Re: Albuquerque Retirement Residence, 8301 Palomas NE,

Approval of Permanent Certificate of Occupancy,

Re: Albuquerque Retirement Residence Grading and Drainage Plan Engineer's Stamp dated 4-10-07 (D19/D25)

Grading and Drainage Plan

M:\ACTIVE\DL\1499\dwg\1499GRD.dwg, 4/12/2007 1:41:36 PM

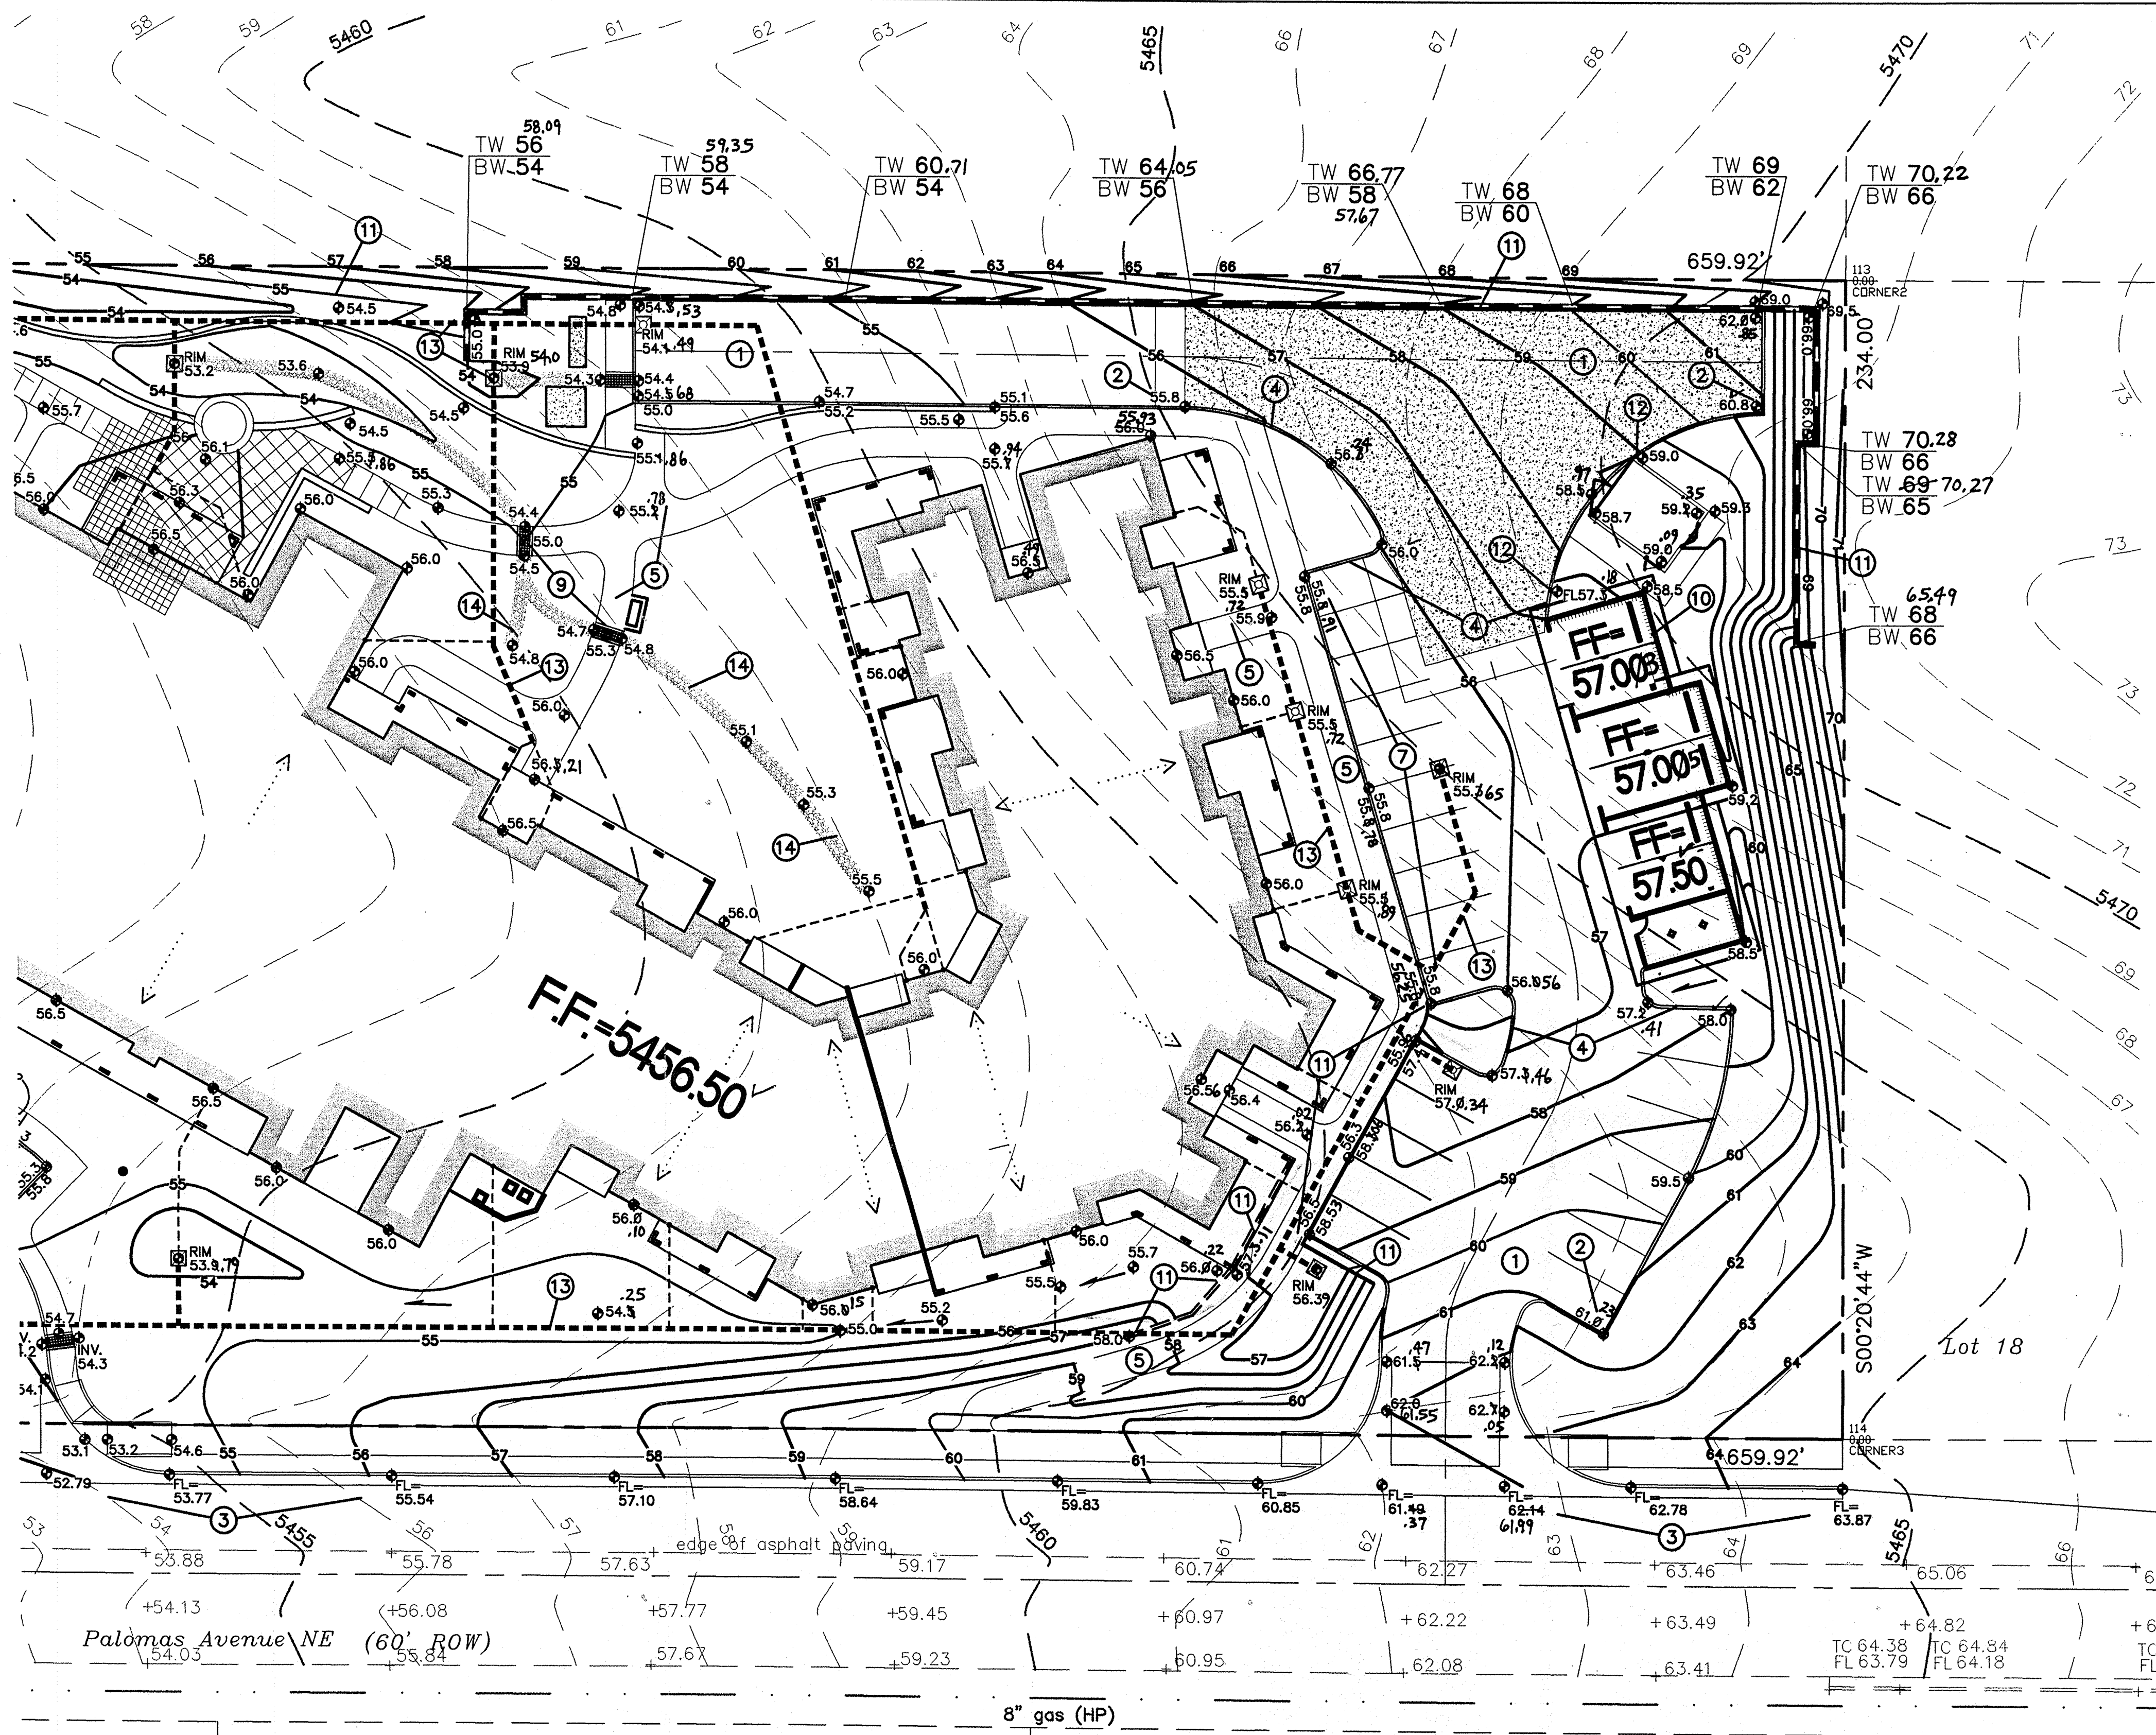
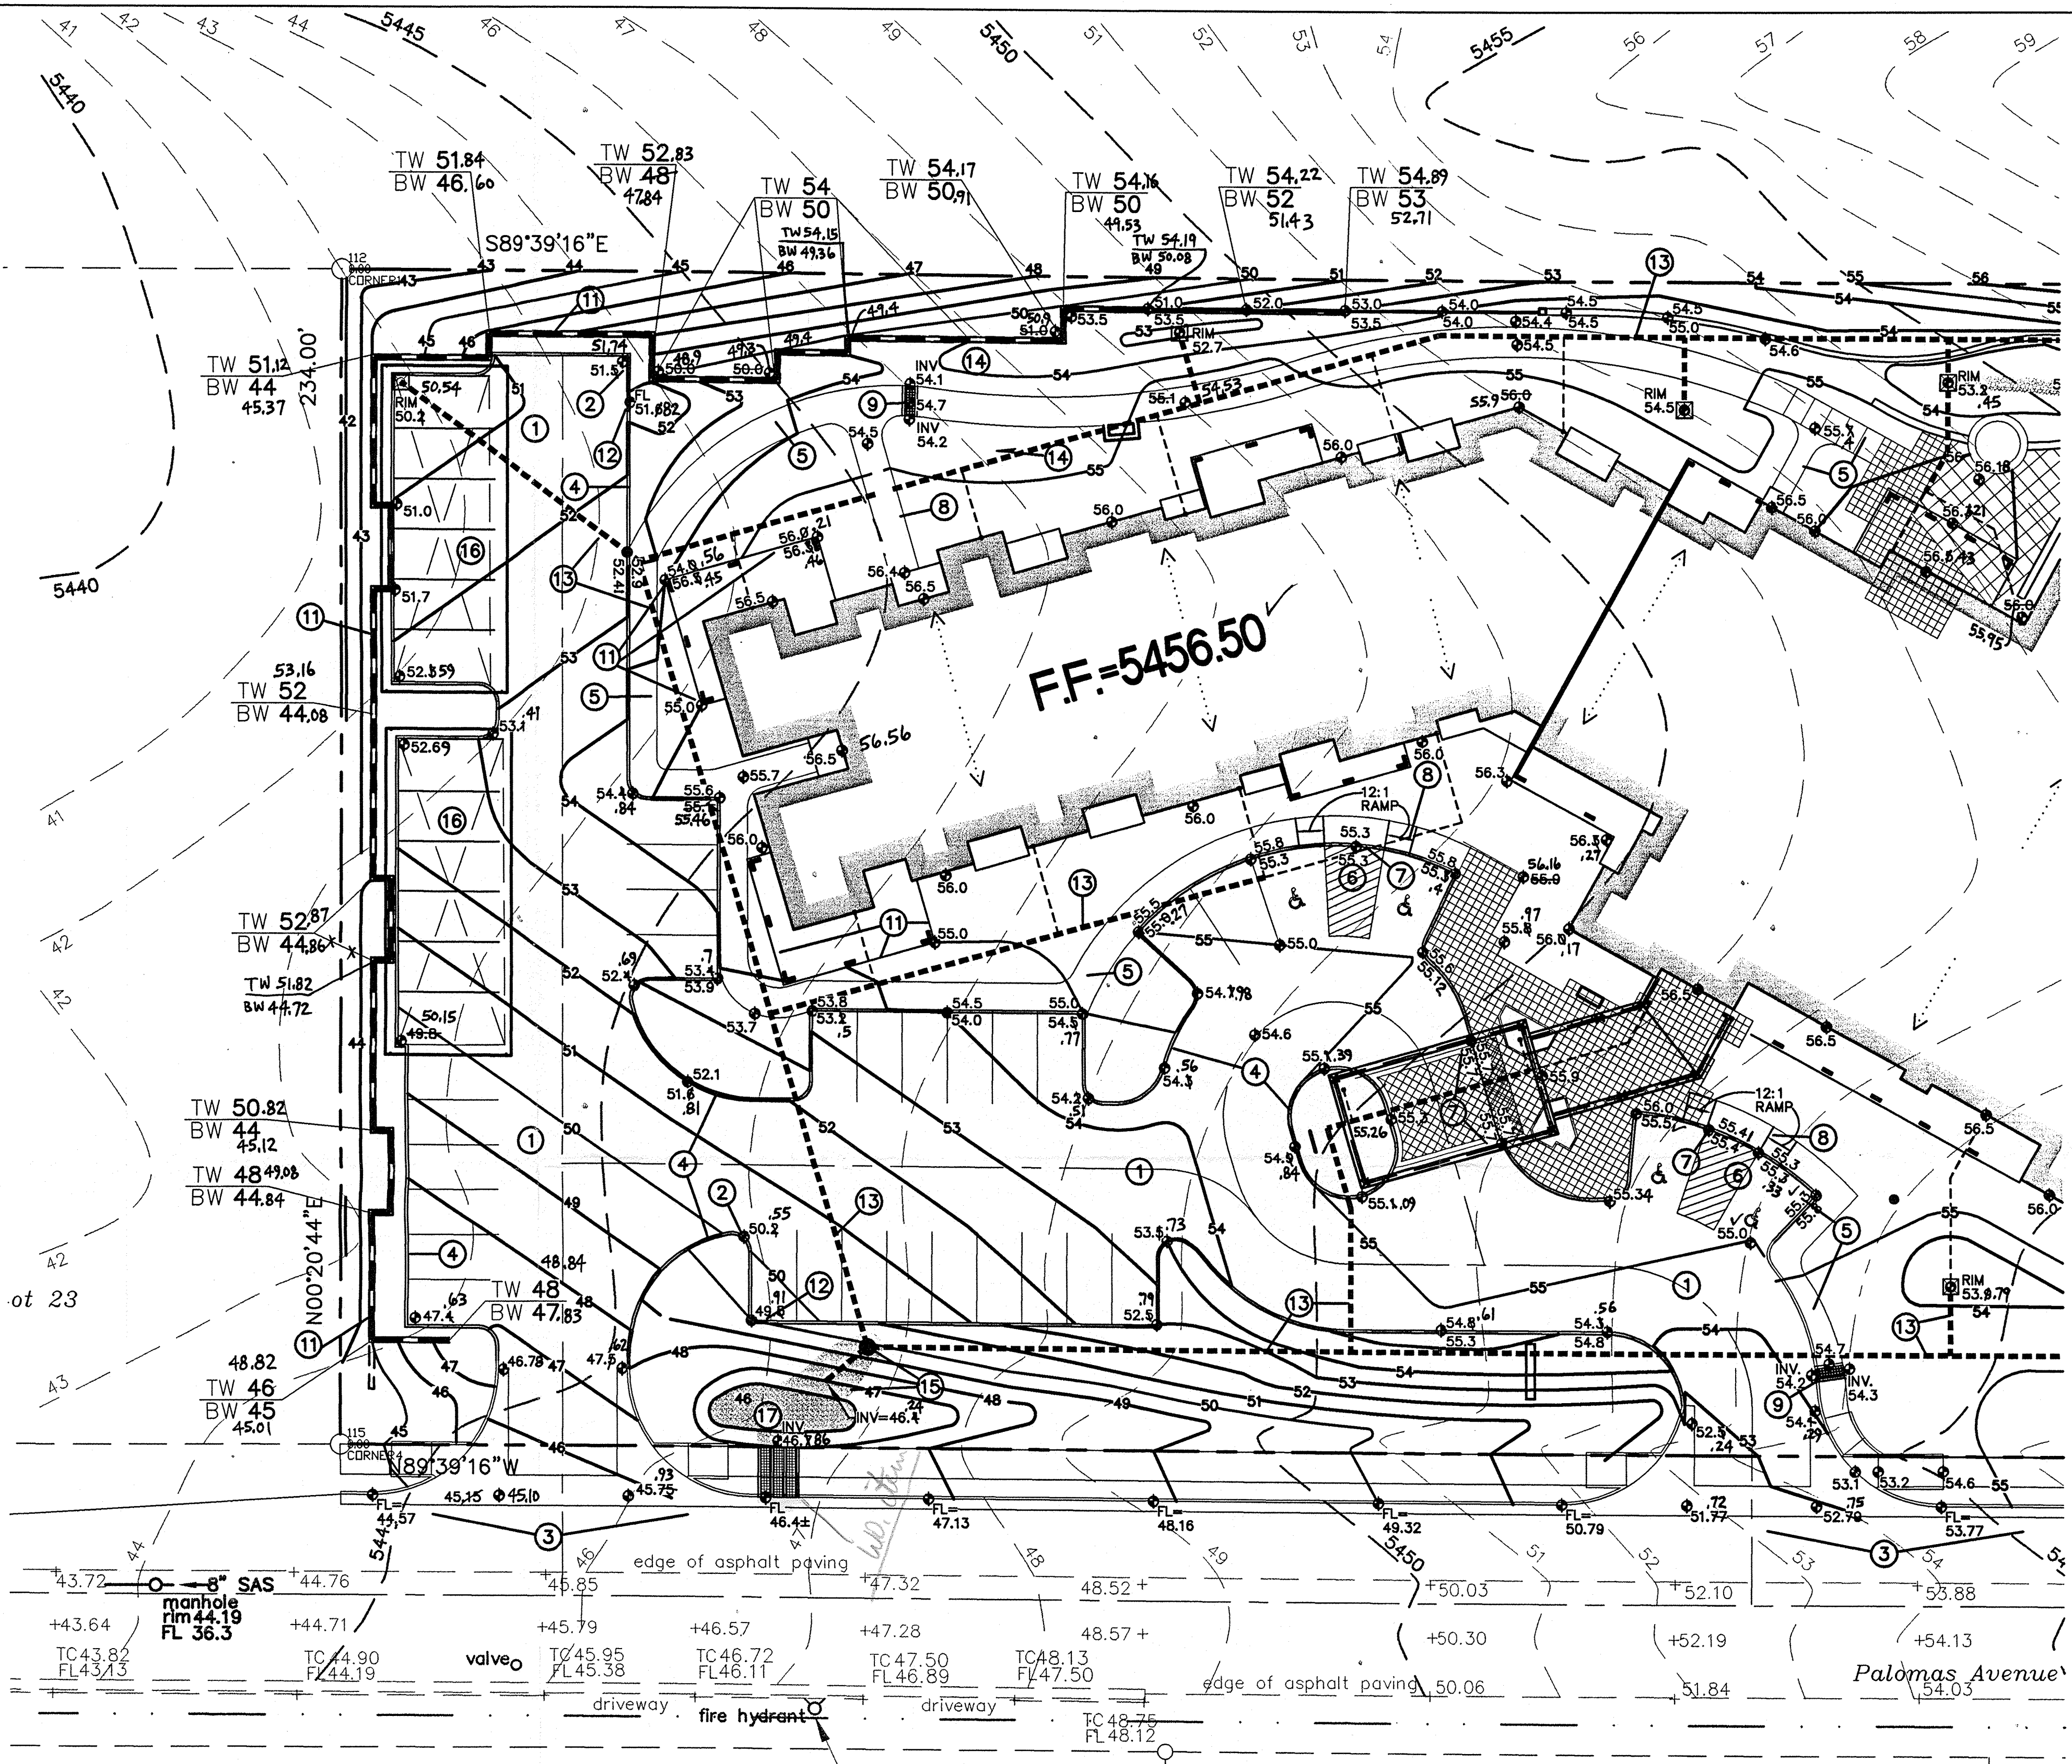
- The slope on the east side of the property that has a slope greater than 3:1 requires an engineer specified means of erosion control. Indicate method used upon certification.
- Engineer Certification per the DPM checklist will be required.
